SUBJECT: Engineering Review Comment
Mountain View Electric Association Inc. (MVEA)

Project Name: Zindorf/McDaniels Road – Minor Subdivision

Project Number: MS226

Description: Proposed development of 4 residential lots located at McDaniels Rd. and N. Log Rd. in Township 14S, Range 63W, Section 11.

ZINDORF SUB. NO. 3 - NE1/4 NE1/4, SEC. 11, T14S, R63W OF THE 6th P.M., EL PASO COUNTY, COLORADO

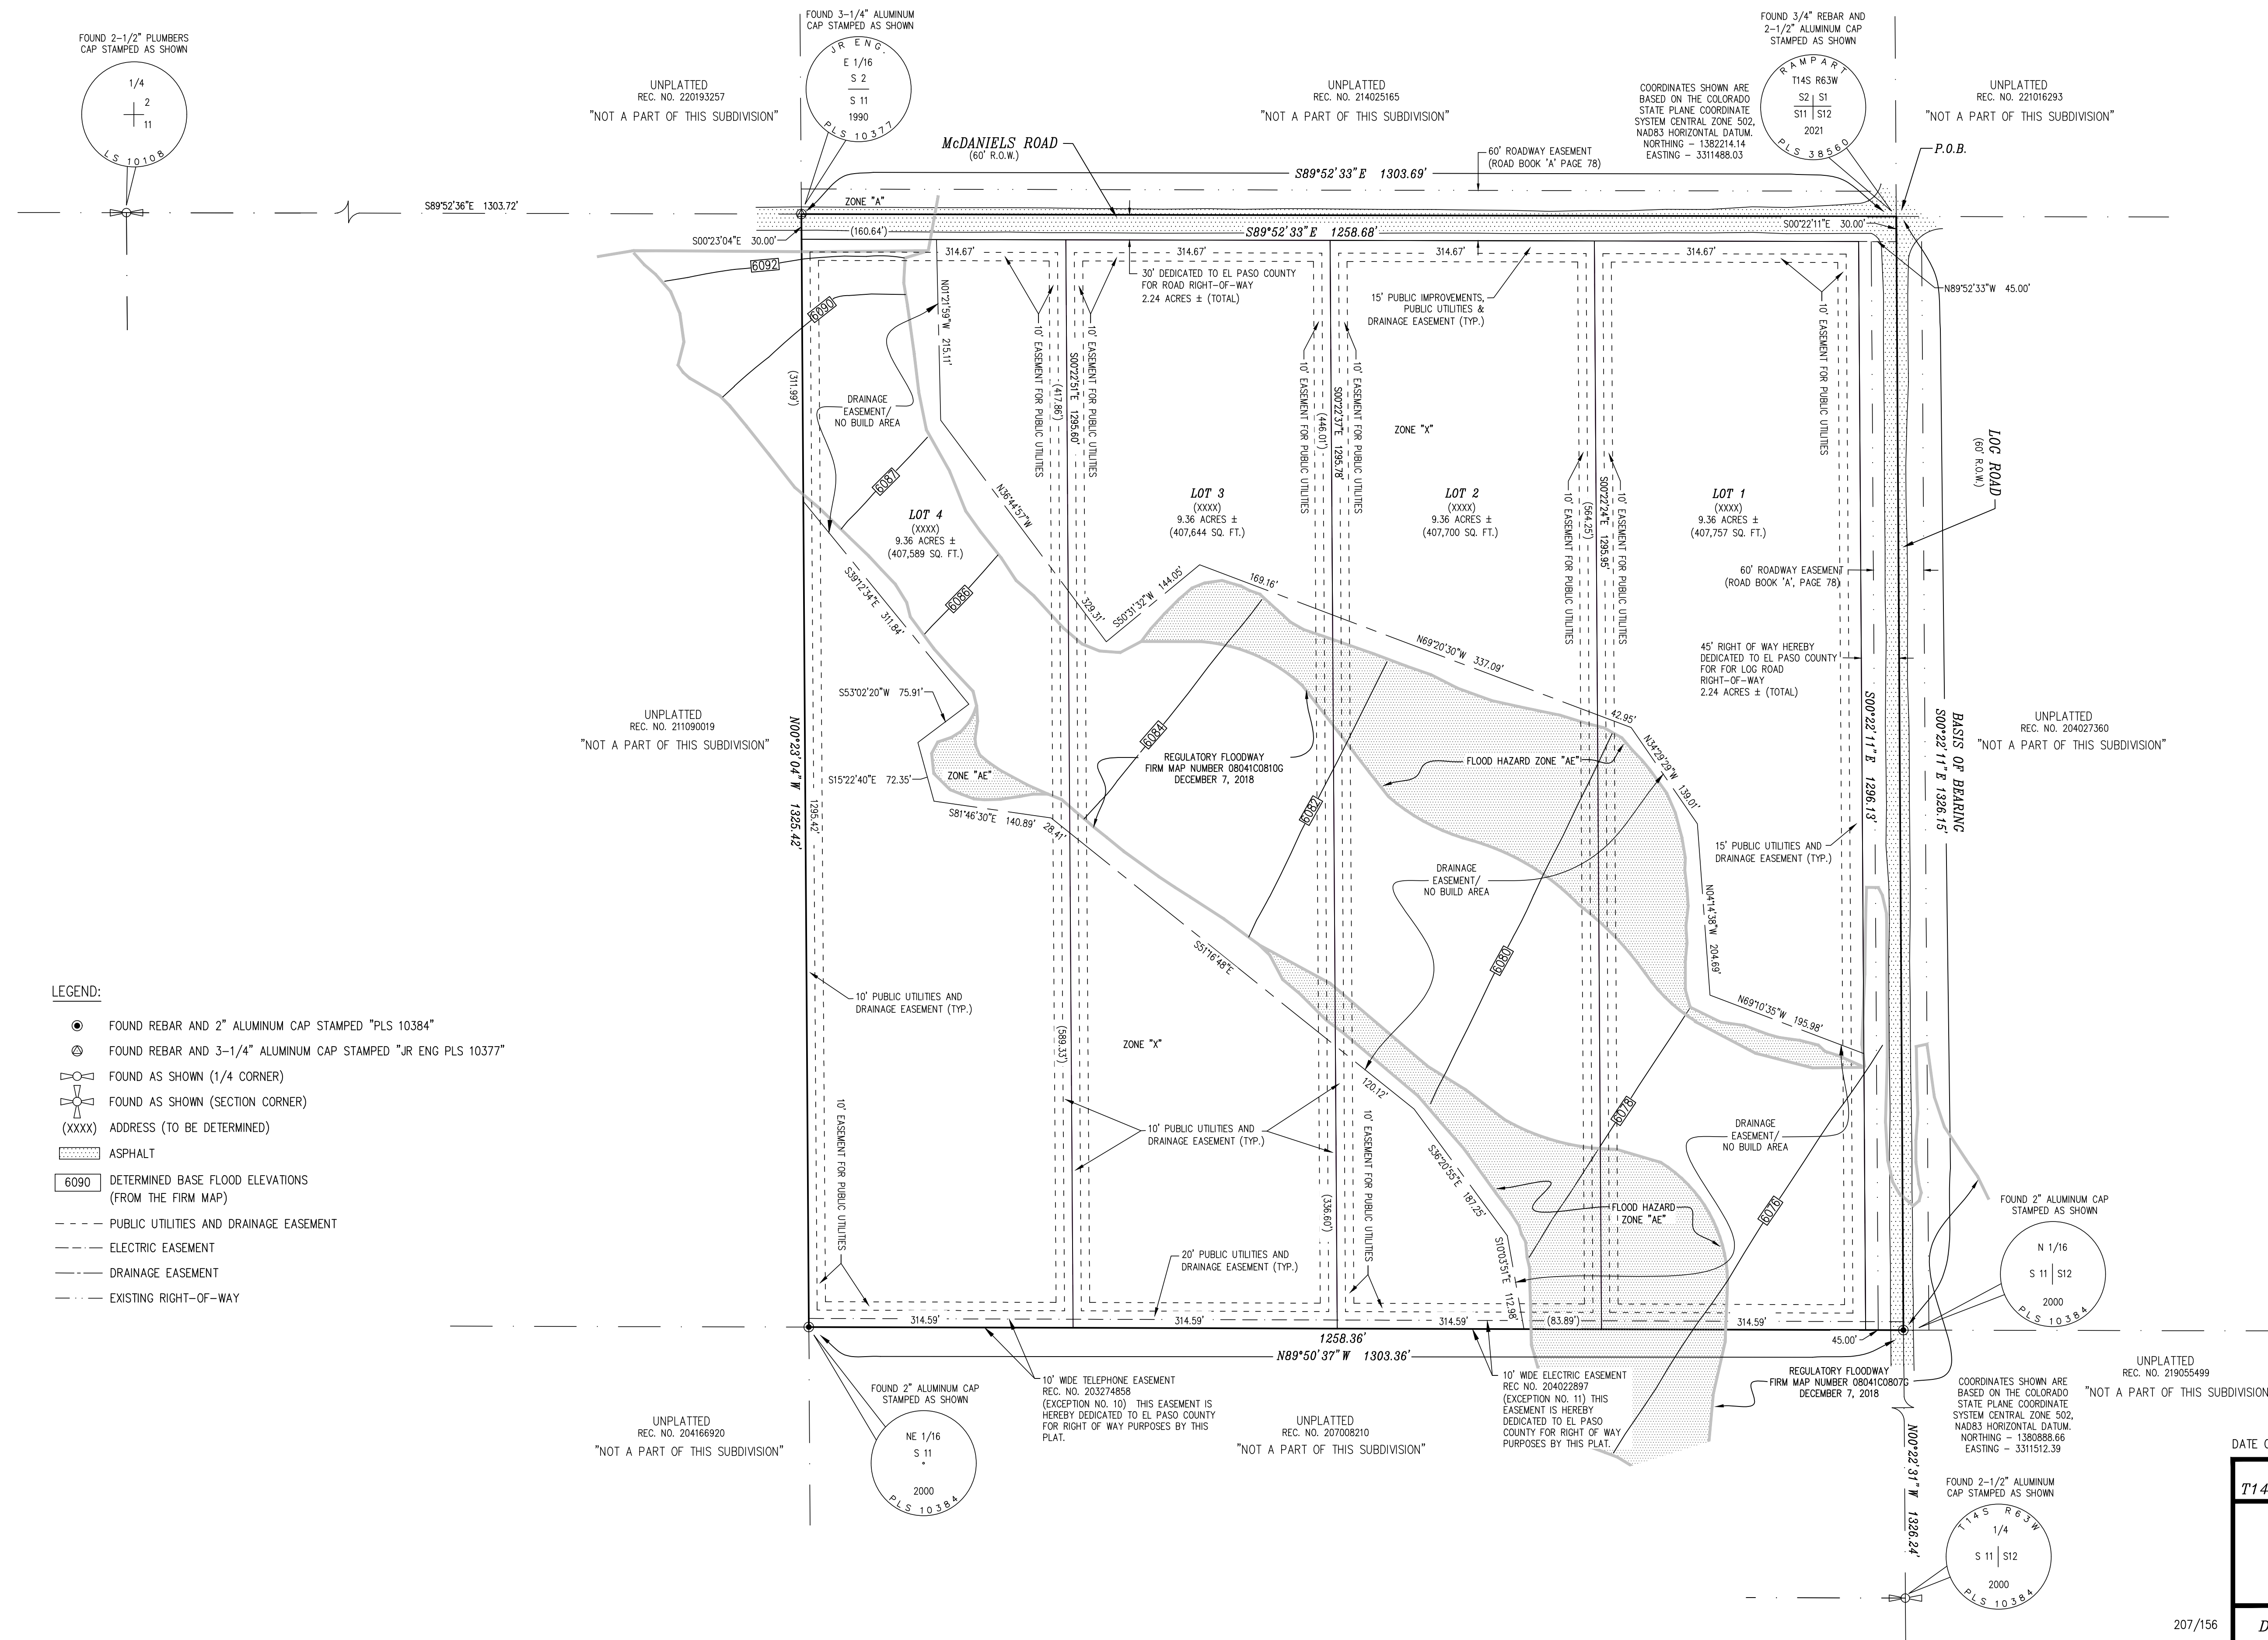
The Association requests a ten (10) foot front, side, and rear lot utility easements in addition to any public improvement easements. The Association also requests the platting of the Association's existing facilities with easements on the plat. Additional easements may be required.

MVEA has existing facilities near and within this parcel of land. If there is any damage, removal or relocation of facilities it will be at the expense of the applicant.
